Subject: Re: 27 Shrubbs Drive, Middleton-on-Sea (M/19/20/HH)

I have now had chance to chat to our Client regarding the annexe at Shrubbs Drive.

Block Plan
Scale 1 : 5 0 0

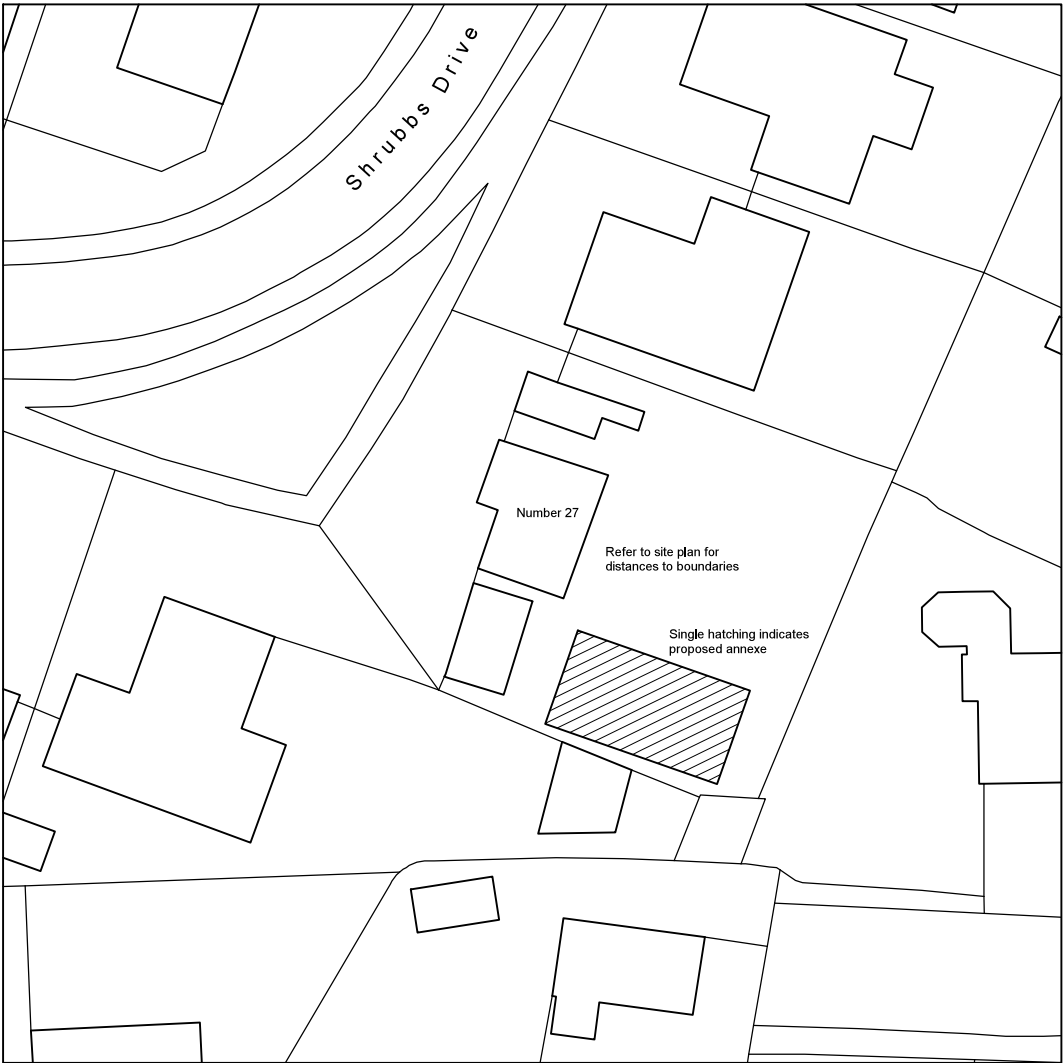
Even with the addition of the annexe, the remaining amenity space is still greater than that of the neighbouring properties as can be seen on the block plan.

Site Plan

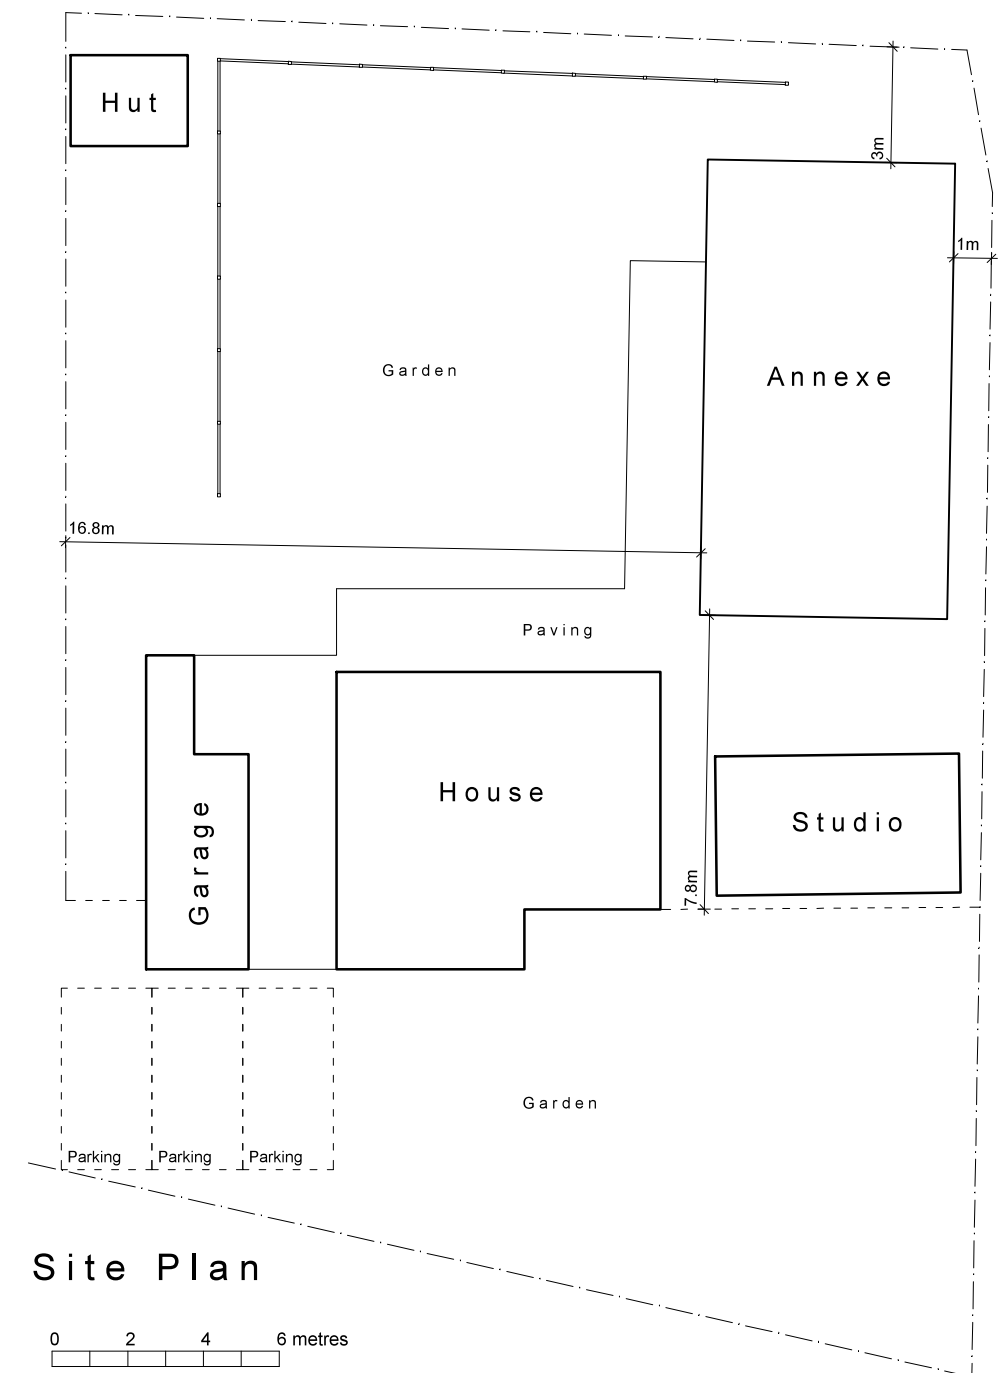
Whilst I appreciate that the pre-application drawings did not show the building in context, our site plan shows that the building does sit comfortably on the site, with adequate distances to the boundaries and ample amenity space.
